**WEST SUSSEX COUNTY COUNCIL
PLANNING SERVICES CONSULTATION**

SUBJECT: AL/129/17/PL - Demolition of existing garage, demolition of portion of flint wall to re-instate pedestrian access onto Nyton Road & erection of 2 No. dwellings with associated car parking, cycle storage, bin storage & gardens. This application may affect the setting of a Listed Building.

Land east of Forge House, Nyton Road, Aldingbourne, Westergate, West Sussex, PO20 3UP

RECOMMENDATION: ADVICE

Location and Site Plans

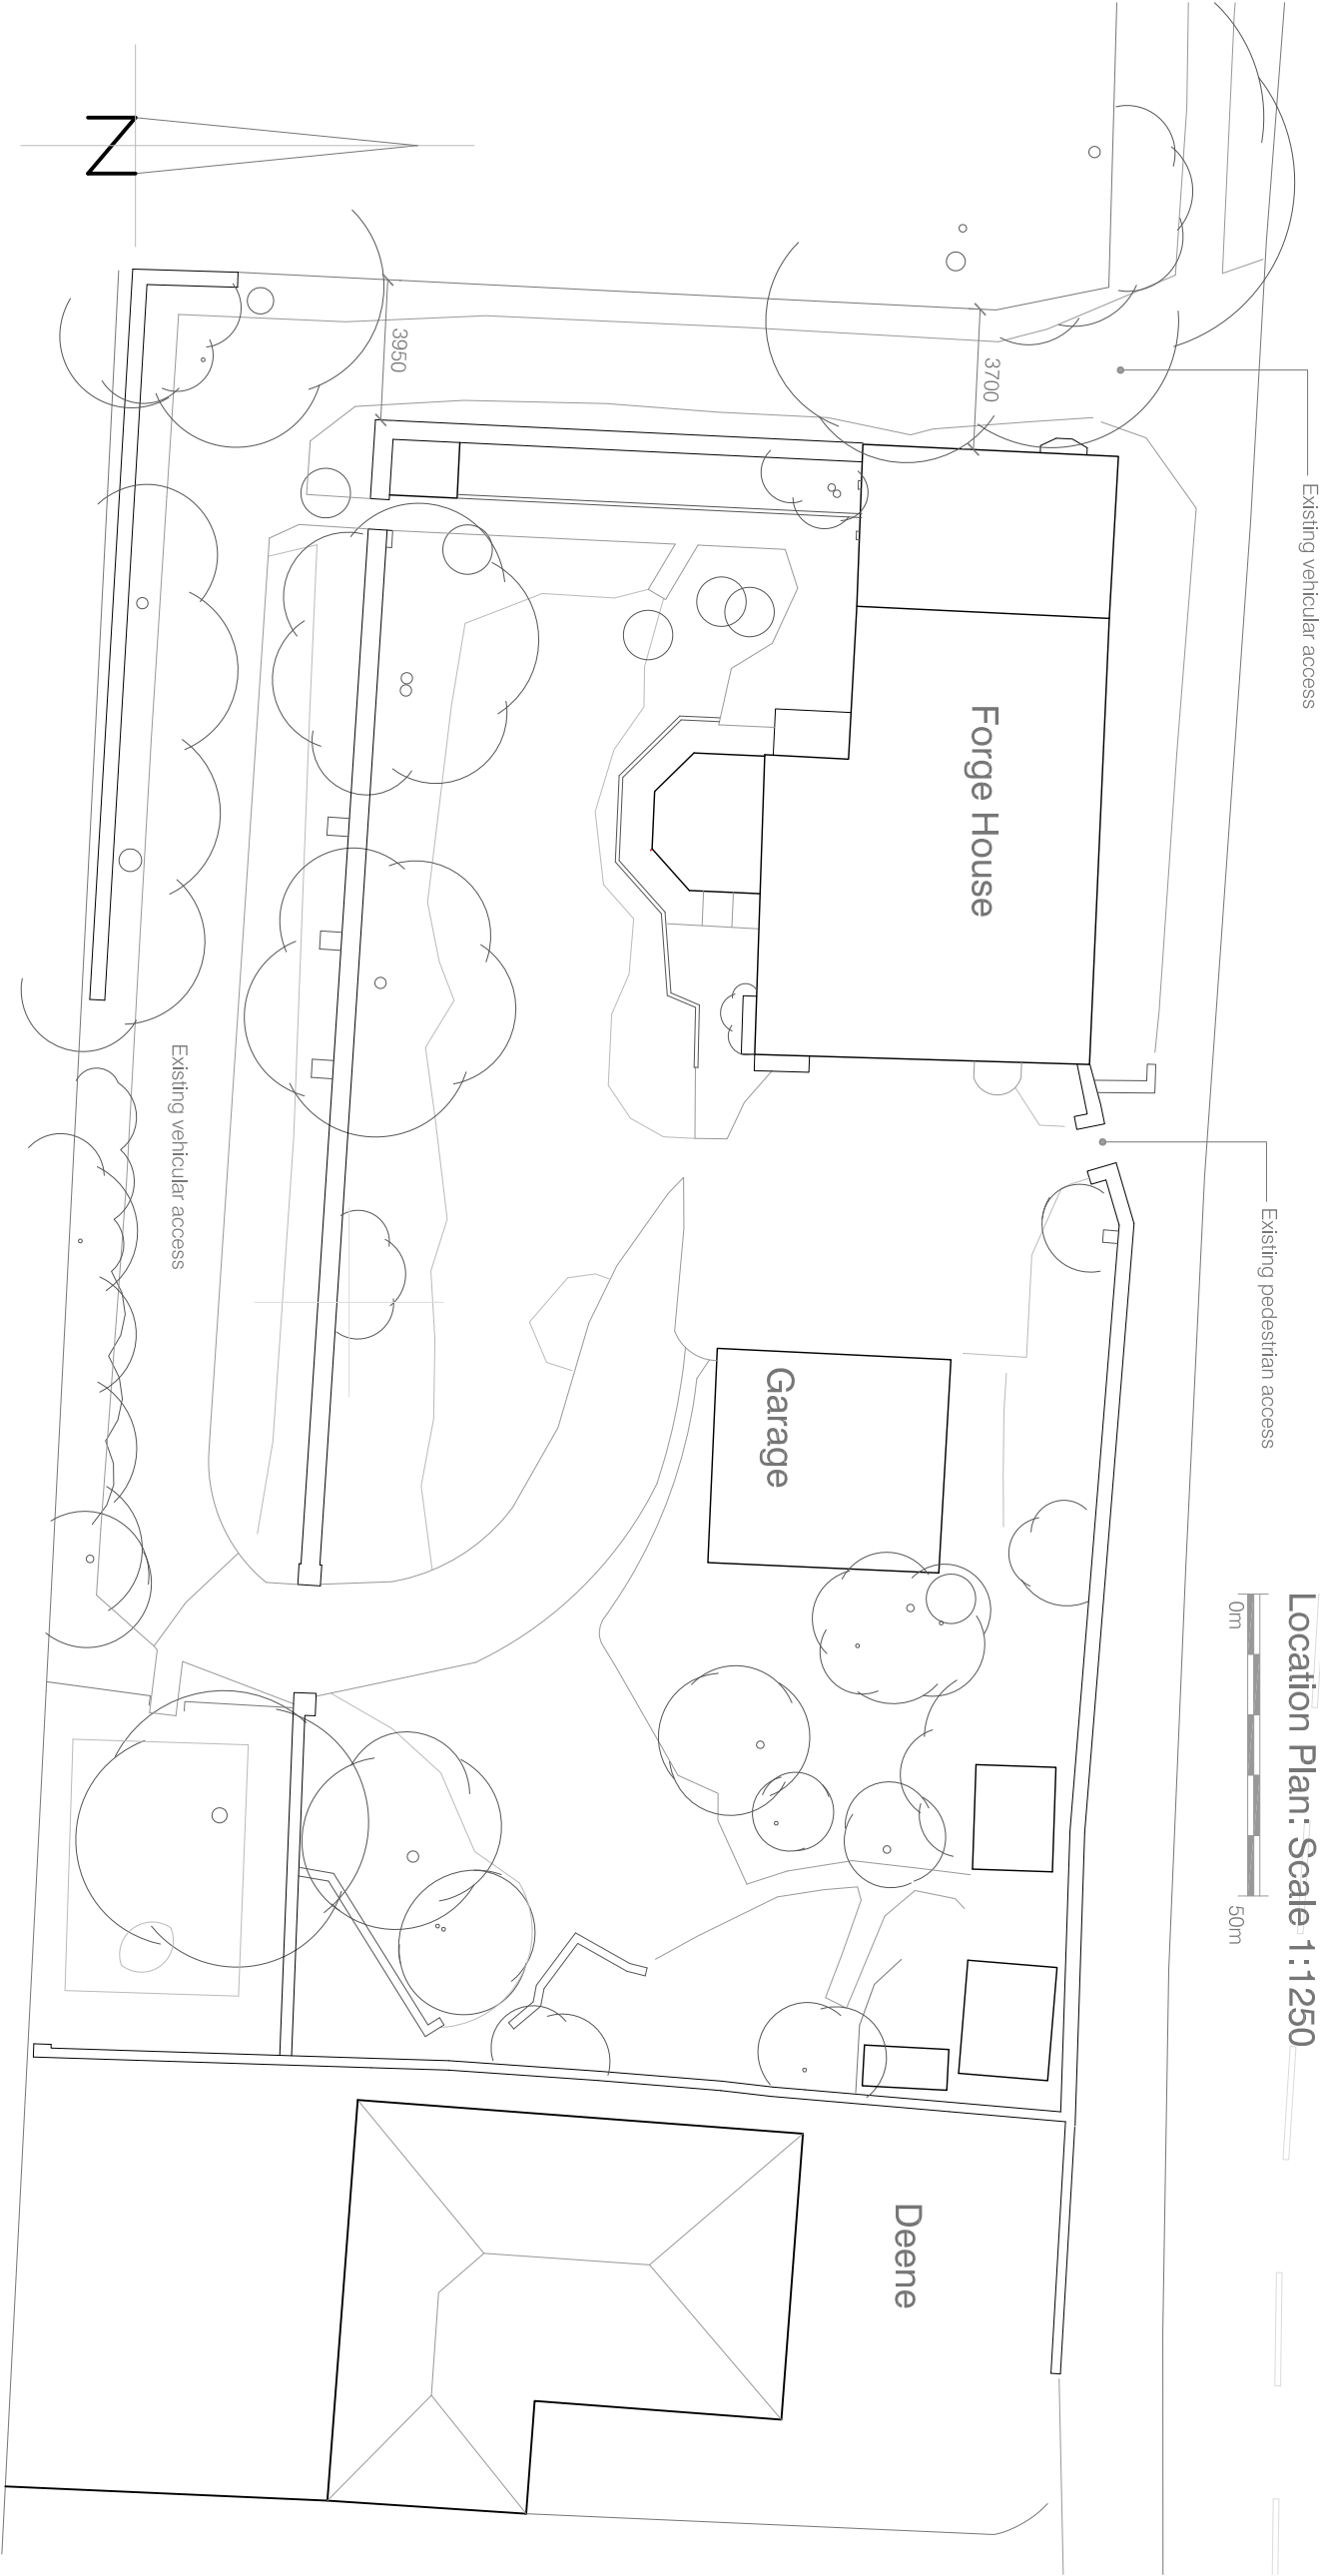
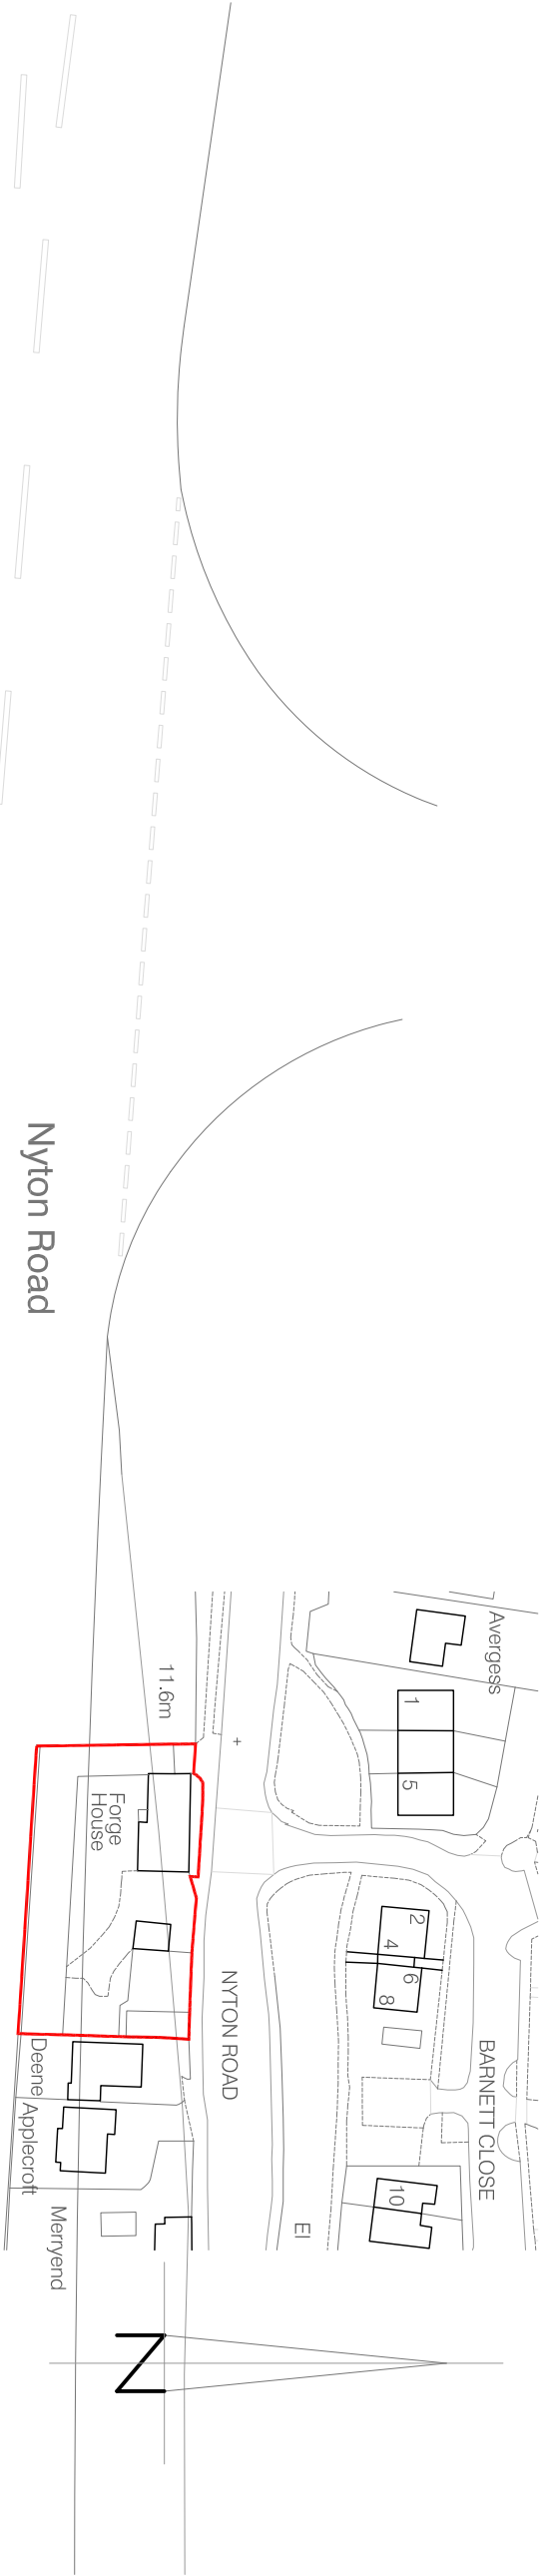
Vehicular visibility splays have not been demonstrated however from an inspection of WSCC mapping splays of 2.4m by 43m entirely within the extent of the public highway are achievable. As per Manual for Streets (MfS) guidance this is suitable for vehicle speeds of 30 mph. Furthermore the existing splayed access provides some scope for pedestrian visibility on the adjacent footway.

It would be beneficial to provide a passing place at the entrance, a width of ideally 4.5m. Nevertheless, the LHA's previous comments still apply whereby, considering the anticipated low level of vehicle movements and tidal nature of these, it would be difficult to substantiate a highway safety reason to resist the application based on this alone.

Whilst the garage for Forge House will be demolished nevertheless some off-street parking for the existing dwelling will be retained. There appears to be sufficient space within this layout to also provide a turn on site facility.

Ground Floor Plan: Scale 1:100

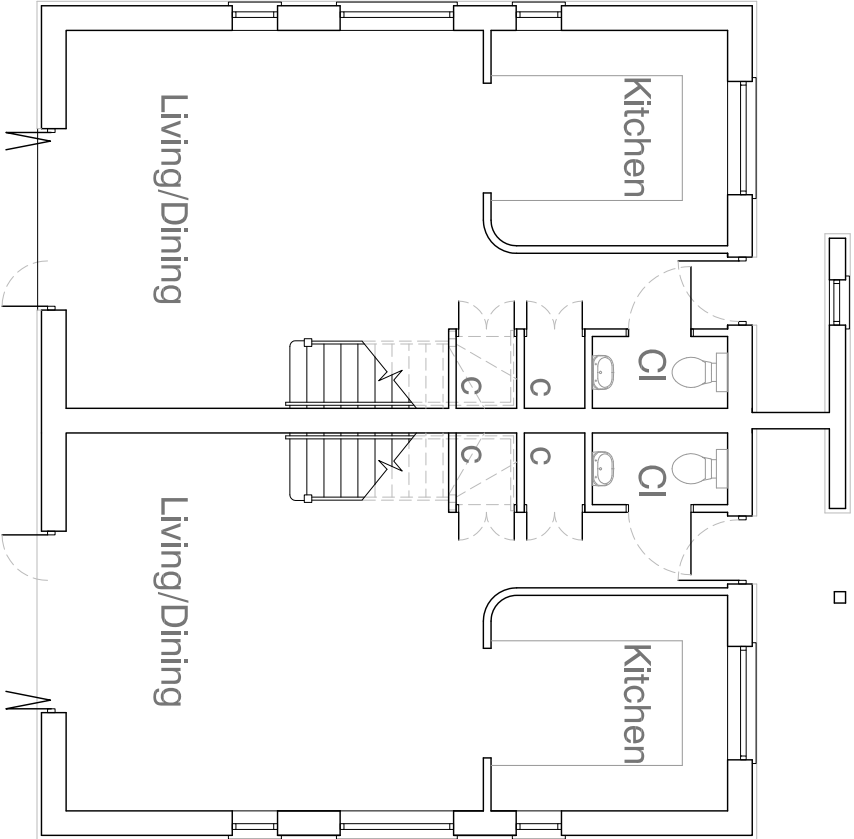
The proposed 2-bedroom dwellings will each be served by 2 x tandem car parking spaces. This meets with the level of parking demand anticipated by the WSCC Car Parking Demand Calculator for dwellings of this scale and location. From an inspection of the plans the proposed parking spaces are at least 2.4m by 4.8m each, sufficient for providing allocated parking to the use.

For a 90 degree turn to/ from a 2.4m wide space MfS advises that 6m clear space rear of the parking bay is available. The presence of boundary vegetation results in a length short of this requirement. Nevertheless the LHA consider that turning will be achievable on site, via a multipoint manoeuvre, and that cars are not anticipated to reverse on to Nyton Road in this location.

No part of the development shall be first occupied until the vehicle parking and turning spaces have been constructed in accordance with the approved plan. These spaces shall thereafter be retained for their designated use.
